February 23, 2024

**Re: American Furniture Demo at 3535 Menaul Blvd NE  
Erosion and Sediment Control Plan  
Engineer's Stamp Date 2/6/2024 (H16E083)**

SHEET:
9

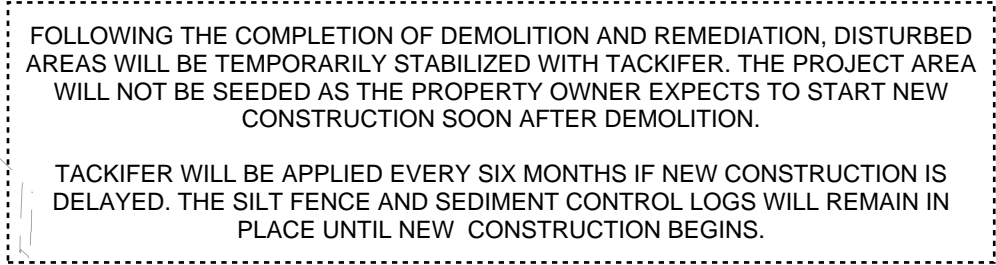
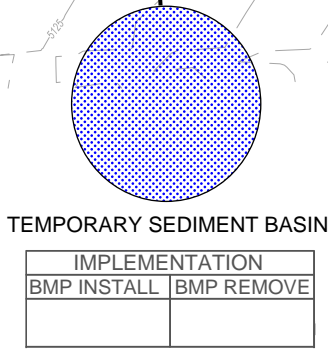
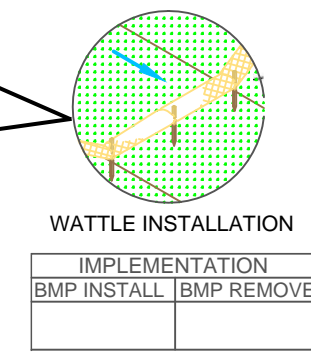
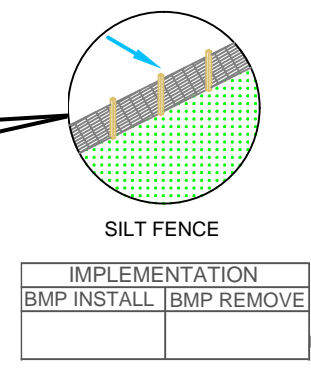
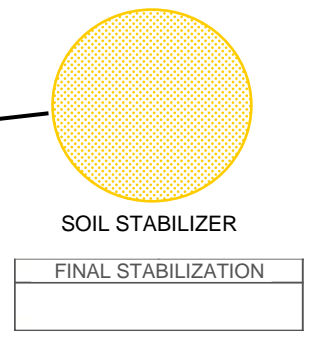
2. There appears to be more than 5 feet of grade change from the southwest corner of the 18" deep sediment trap to the northeast corner, so more detailed construction standards and specifications will be needed to construct the sediment trap. A berm should be used to divert onsite stormwater runoff from the west side of the site into the sediment trap. A linear retention pond may fit the terrain better than the berm pond combination since the west property line is nearly level over most of its length. The notes on sheets 2 and 9 must be revised to say the pond and berm should be the first items of construction, along with the rest of the temporary stormwater controls. Design finished contours and velocity dissipation devices for the pond and berm per CGP 2.2.12.e.
